TOWN AND COUNTRY PLANNING ACT 1990

Reference:	H14-0678-26	Date of Decision:	14th September 2026
Applicant:	Mrs T Hull Highfields House Highfields Lane Pinchbeck Spalding PE11 3PT		
Location:	25 Orchard Close Pinchbeck Spalding		
Description:	Proposed first floor extension and alterations

J218-PL 2B

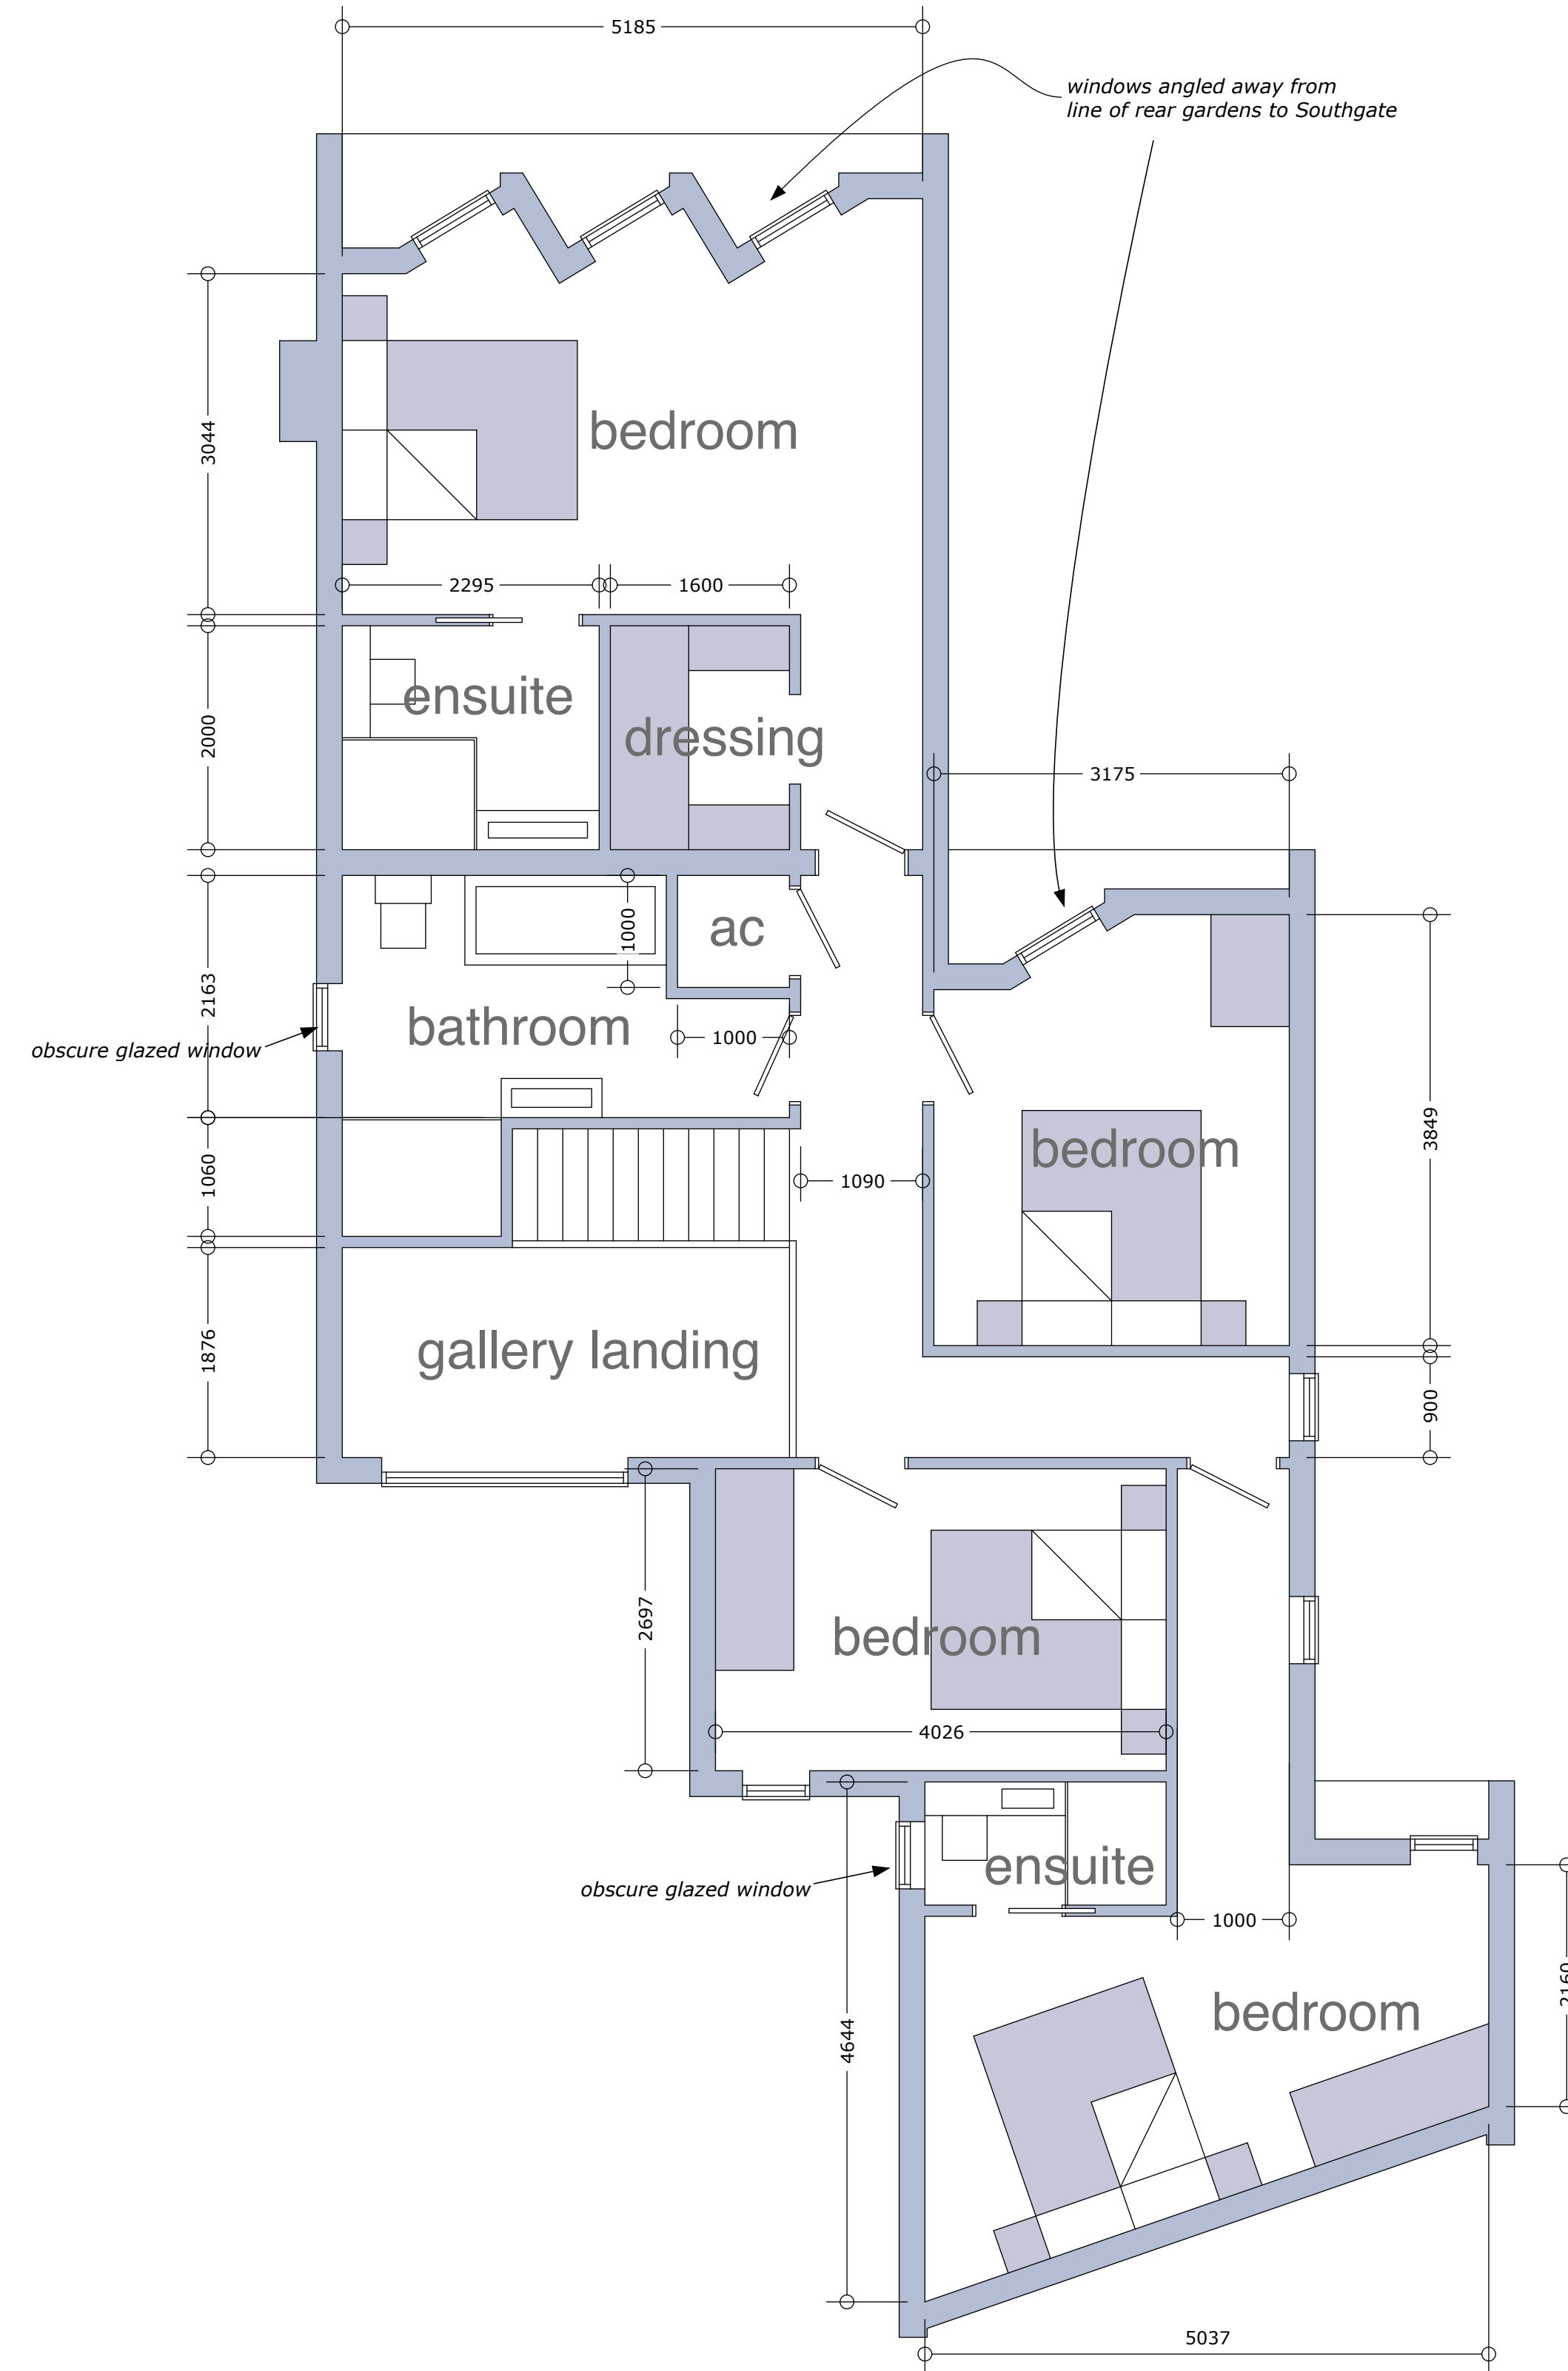
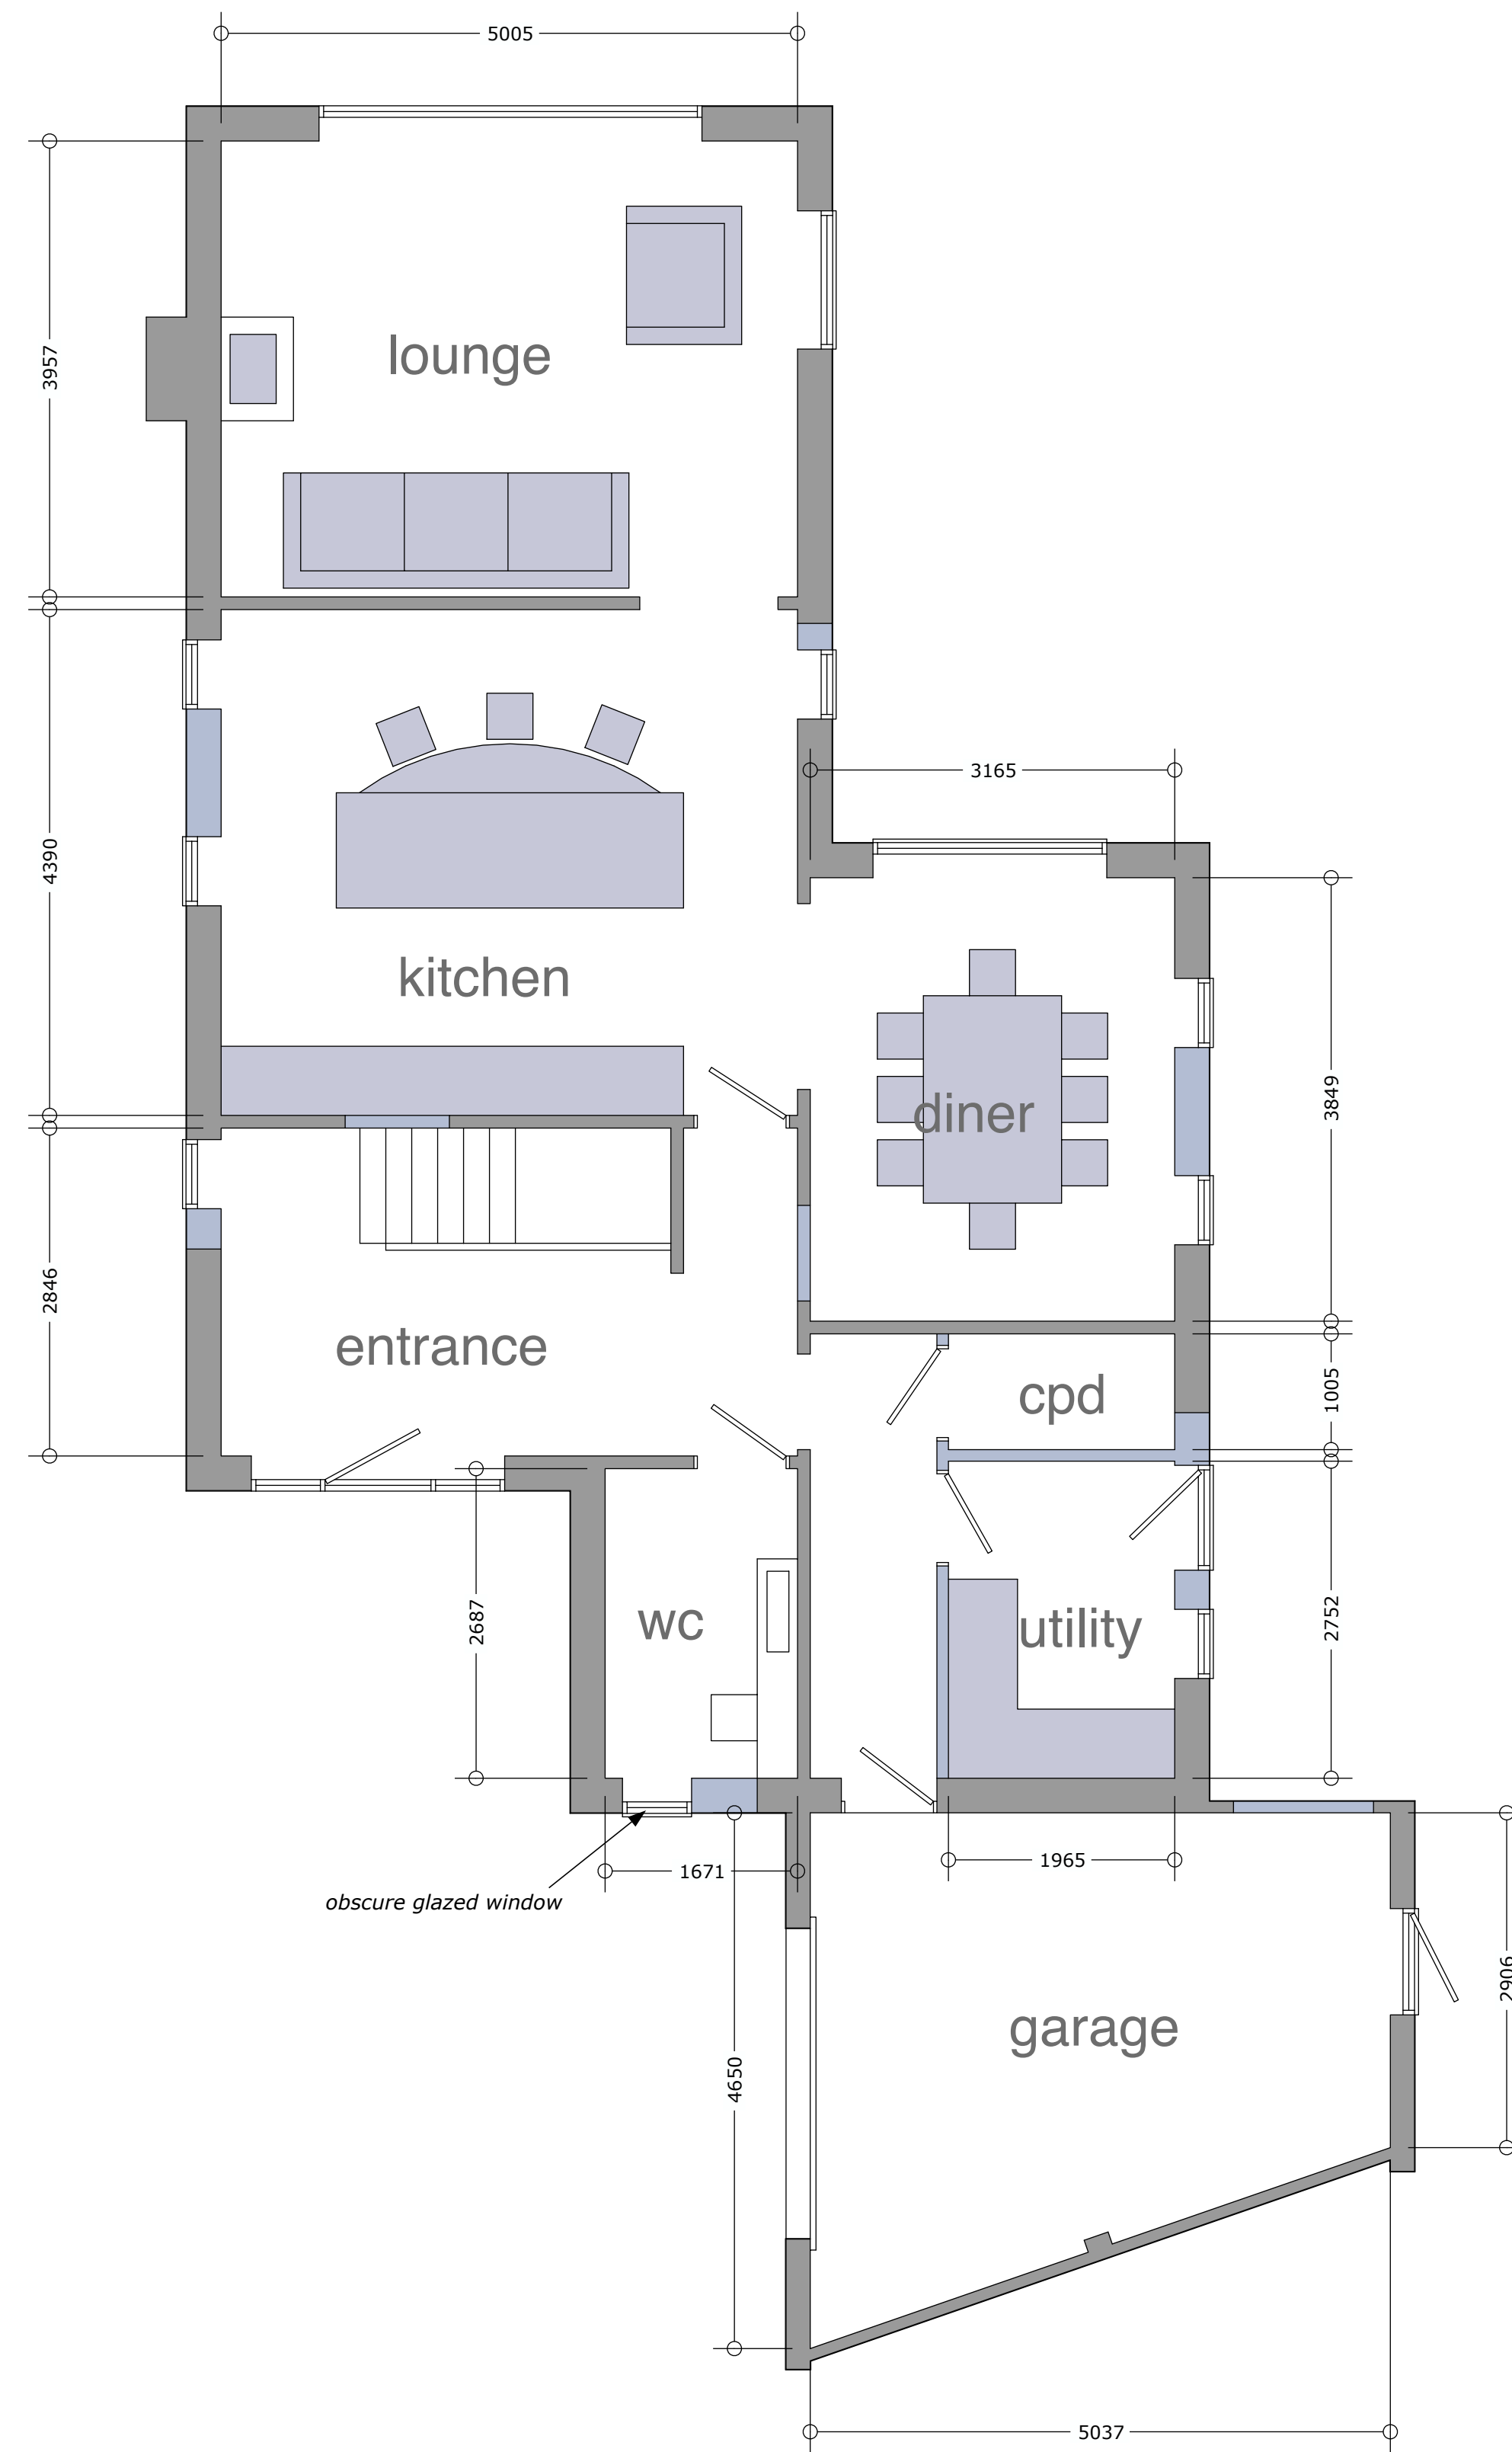
The extension itself would increase the floor space by a total of 84% whilst also increasing the total height by 1800mm, the scale of this is therefore considered to be a fundamental increase which would alter that of the existing character within the plot to such an extent that it would no longer resemble the existing residential bungalow. Two storey dwellings are notable within the area, however, the concern relates to the overall significant increase and disproportionate design proposed.

Beyond this, the proposal seeks to incorporate white rendering on the ground floor, natural slate cladding and dark vertical cladding around the windows to the first floor. The

roof would also be constructed from dark grey metal with dark aluminium on the windows. The surrounding area notably features uniformity through a clear and identifiable palette of brickwork, typical for an estate of this era. As such, it is considered that the vast expanses of rendering and cladding throughout such visible and prominent elevations would cause harm to the ubiquitous character along Orchard Close, Southgate and Harpe Close.

The modern design philosophy adopted within this scheme fails to respect, and vastly juxtaposes, the existing context throughout and results in significant harm to the character and appearance of the area.

- 2 The construction of a first floor extension within this location, paired with its overall height, introduction of various first floor windows and proximity to boundaries would result in significant and material harm overlooking, overshadowing and overbearing aspects which would result in a loss of privacy and loss of light.

Such views would be clear and uninterrupted towards the rear gardens of No. 23 and 25 Harpe Close with there being no permanent structure or foliage acting as an element of concealment. Furthermore, a shadow is considered to be cast towards the eastern and western neighbours as a result of the height of the extension and location within the plot. Finally, the height and proximity to the boundaries would create significant expanses of built form which would appear overbearing toward the neighbouring properties on Harpe Close and Southgate mainly.
